City of Portland, Maine - Building or Use Permit

Permit No: 03-0762	Date Applied For: 06/25/2003	CBL: 437 A011001
------------------------------	--	----------------------------

Location of Construction: 77 Mona Rd	Owner Name: Cobb Charles H Heirs	Owner Address: 77 Mona Rd	Phone: () 797-4487
Business Name:	Contractor Name: Maine Wide	Contractor Address: PO Box 2106 Augusta	Phone: (800) 452-1940
Lessee/Buyer's Name	Phone:	Permit Type: Additions - Dwellings

Proposed Use: Single Family w/Garage	Proposed Project Description: Construct a 24' x 28' Two Car Garage
--	--

SKETCH PLAN OF LAND
AT
77 MONA ROAD
IN
PORTLAND
CUMBERLAND COUNTY,
MAINE

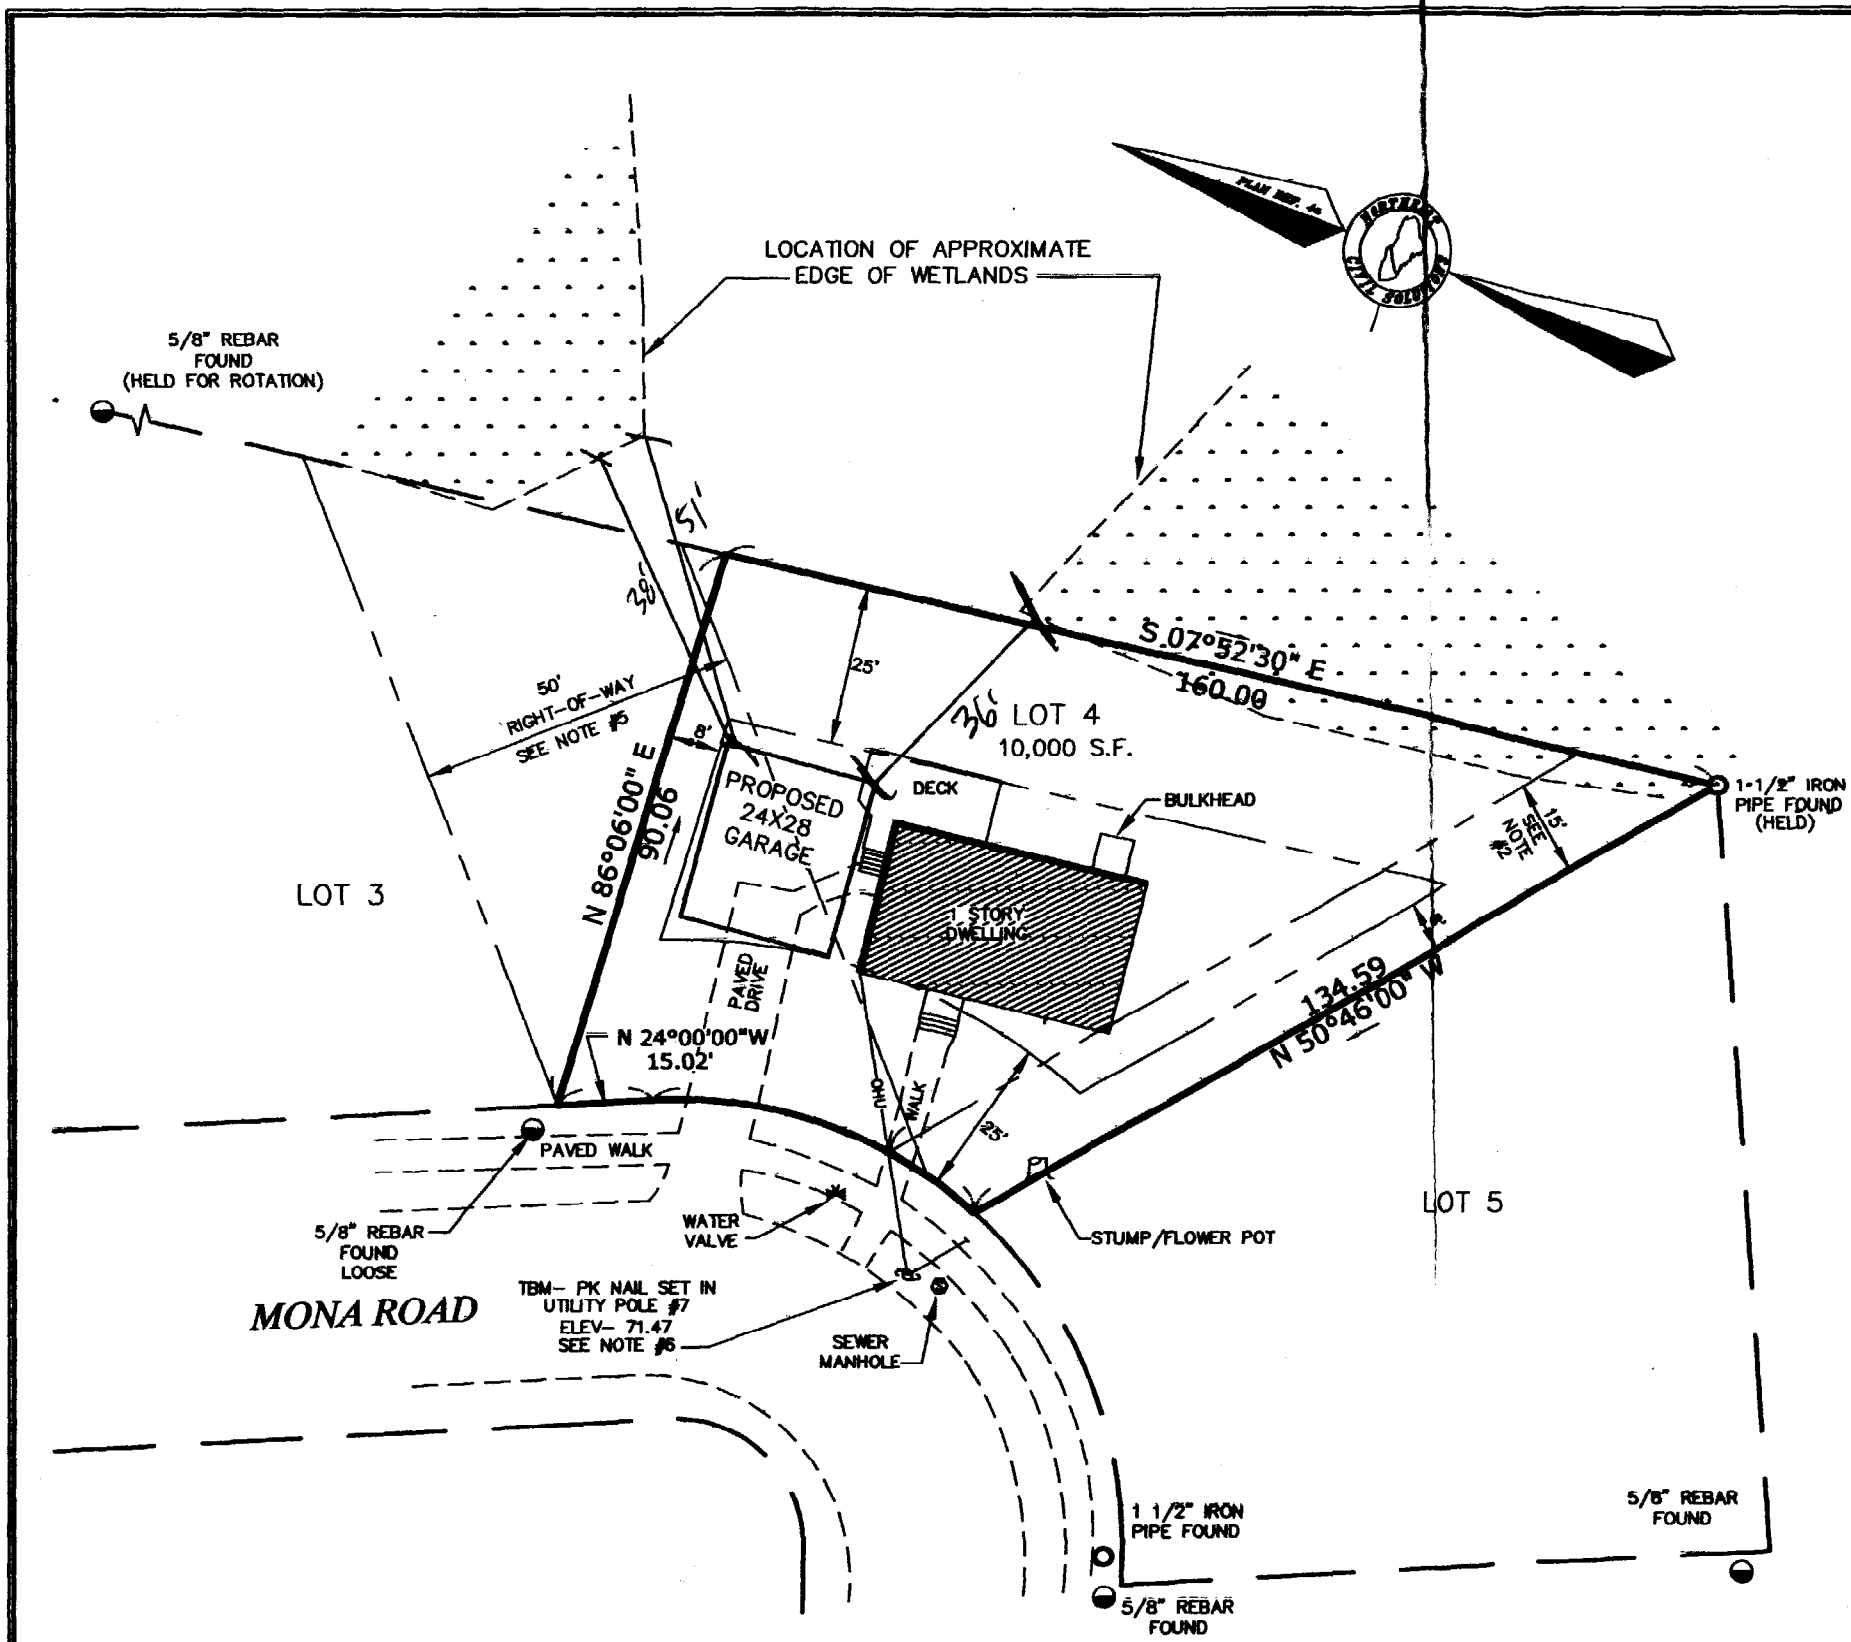
Dept: Zoning	Status: Pending	Reviewer: Jeanine Bourke	Approval Date:
Note: 7/9/03 left vm w/Charles C. regarding shoreland zone and 75' HWM and base flood elevation. 7/14/03 Spoke w/Jim Fisher from NCS and he will inform the client of need for HWM distance for min. 75' setback, verification of ROW release, and elevation certificate. 7/23/03 Tim from Maine Wide called to verify all that is needed and frost protection requirement.			Ok to Issue: <input type="checkbox"/>

- a. All principal and accessory structures shall be set back at least seventy-five (75) feet from the normal high water line of water bodies, tributary streams, or the upland edge of a wetland, except that in the following zones the setback shall be as indicated:
 - i. B-3: Twenty-five (25) feet.
 - ii. W-C, W-PD, W-SU, I-B: No setback required.
